Ribble Valley Borough Council
Development Control

Application no: 3/2019/0498

Address: Land Adjacent to Chatburn Old Road, Chatburn
Proposal: erection of Single Detached Dwelling

site plan as proposed

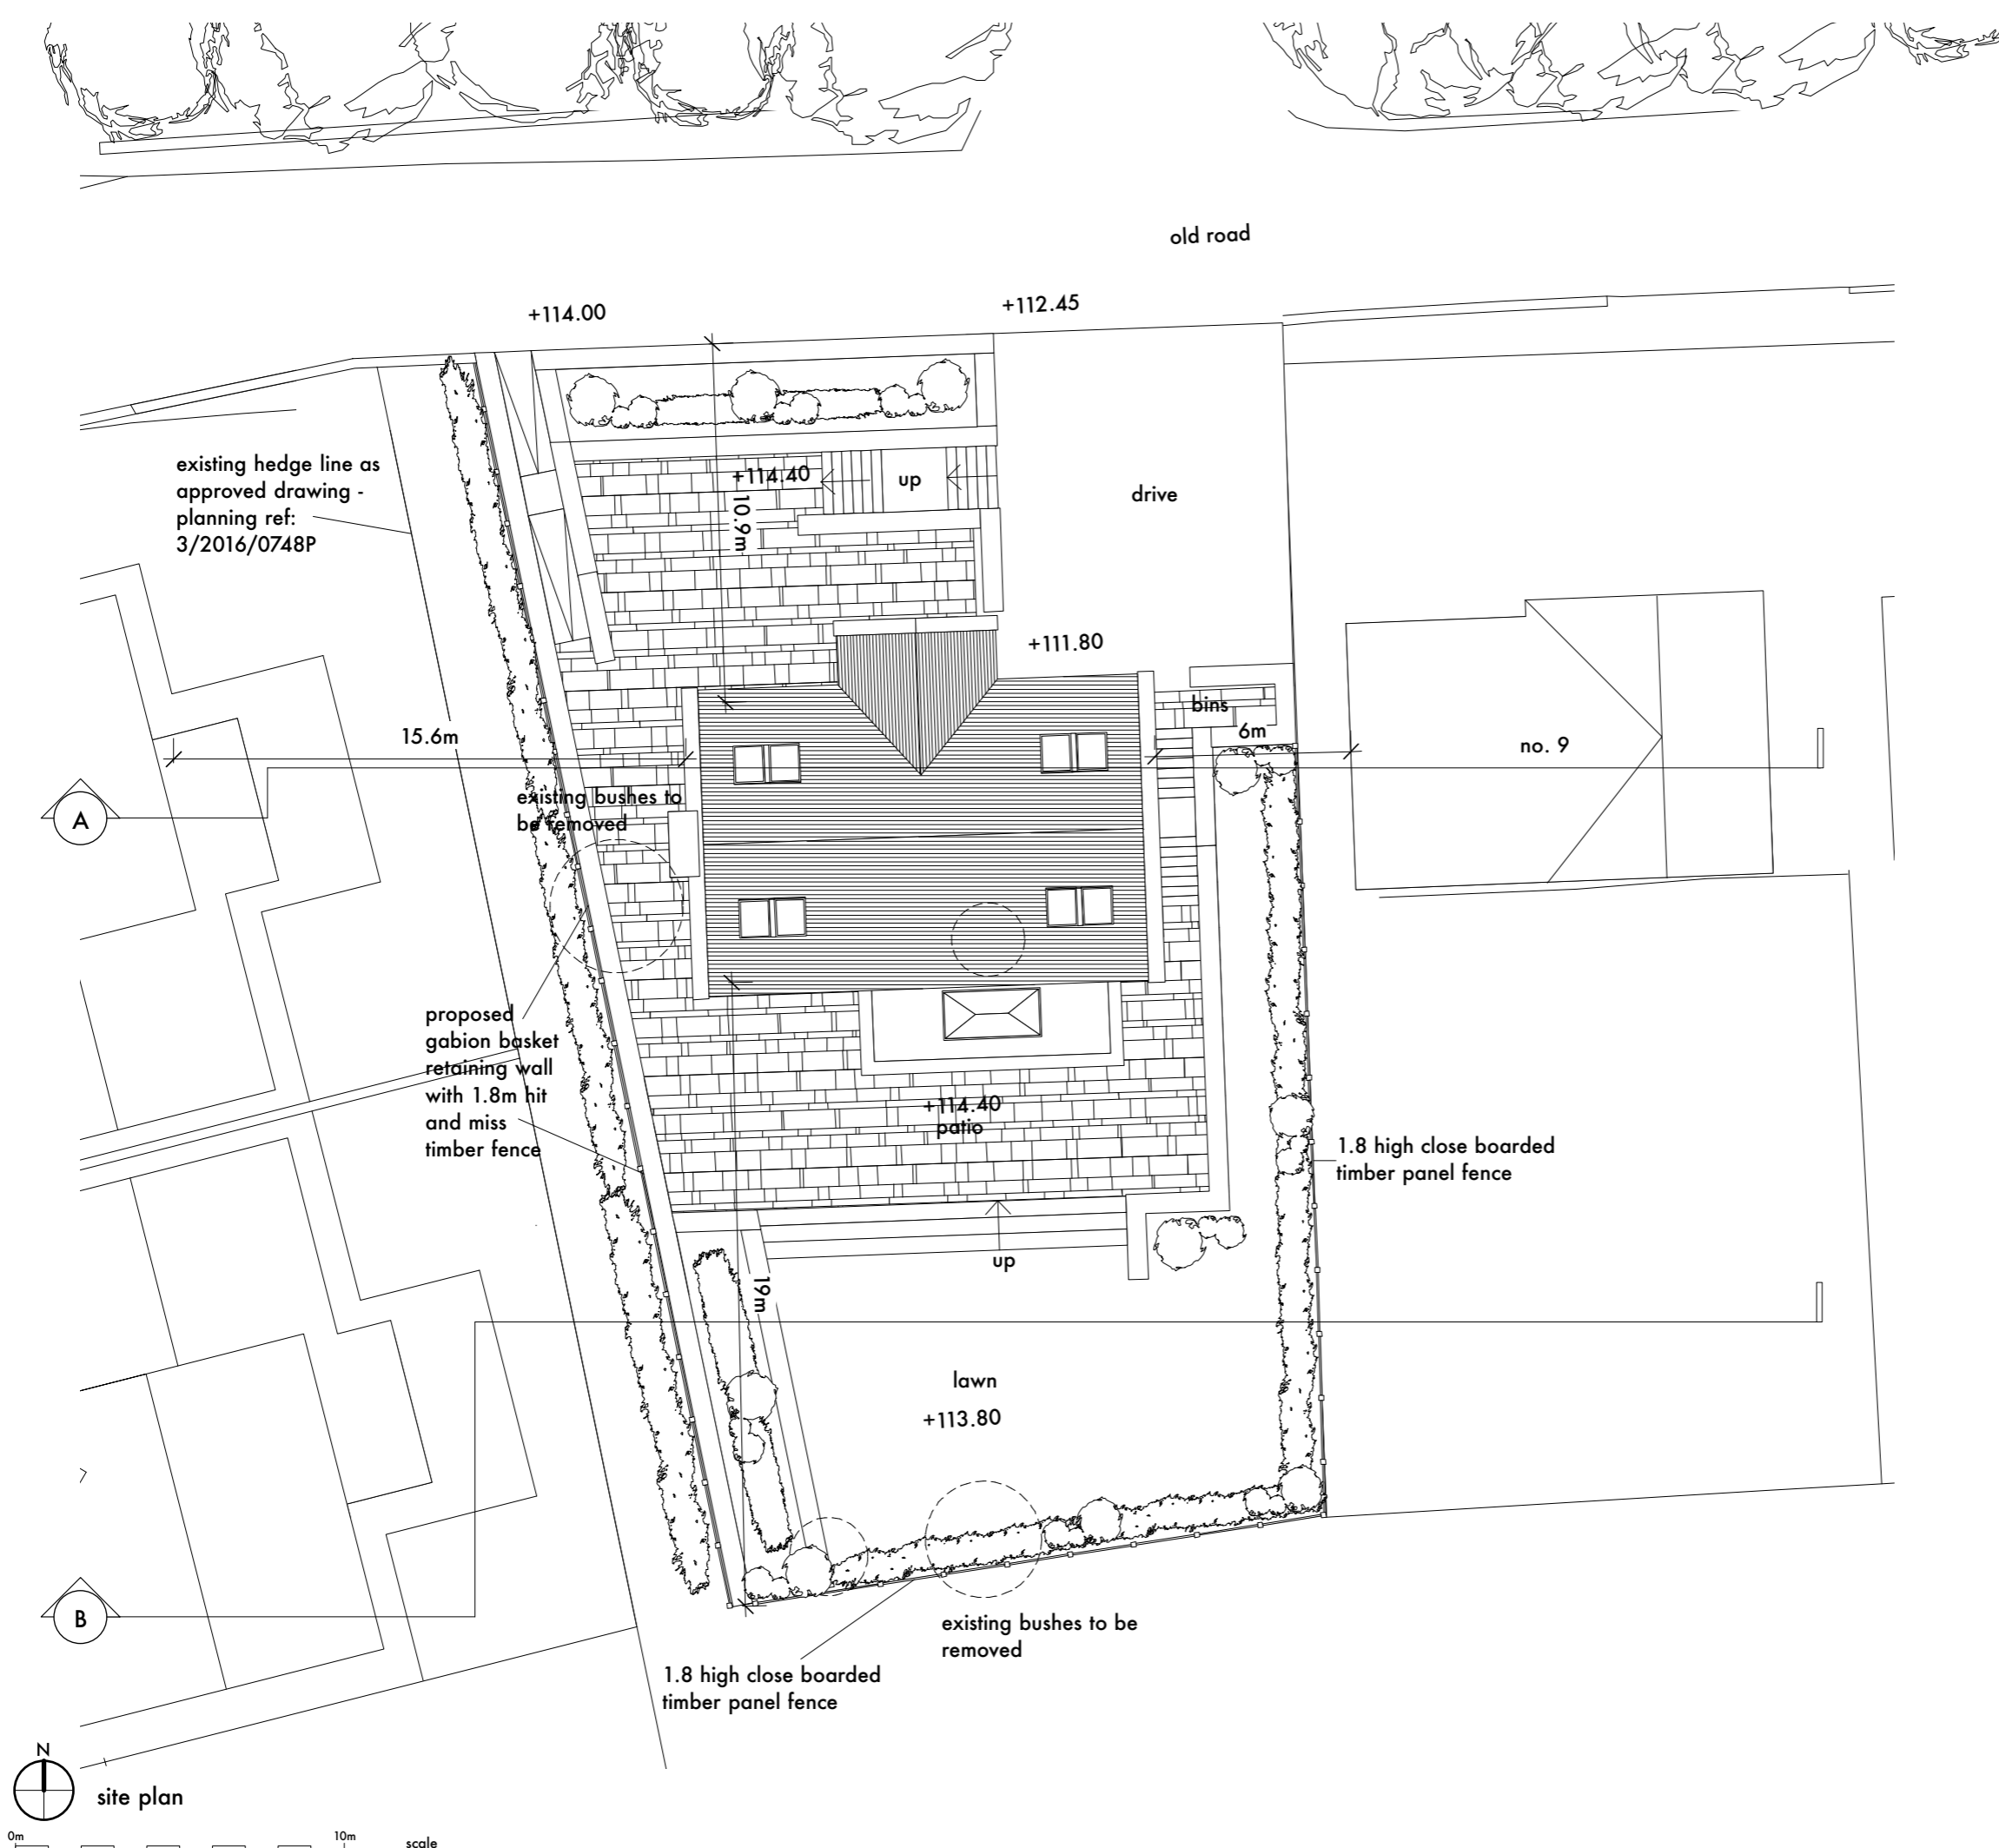
The proposal is for a single detached dwelling to be erected on land between No 9 Chatburn Old Road and a small residential development of 10 units. As proposed the development is acceptable in highway terms but I would need further clarification regarding the proposal for the land to the front of the retaining wall fronting Chatburn Old Road. I would need to be assured that the treatment of this area, vegetation or otherwise will not impinge on the sight lines available when exiting the drive.
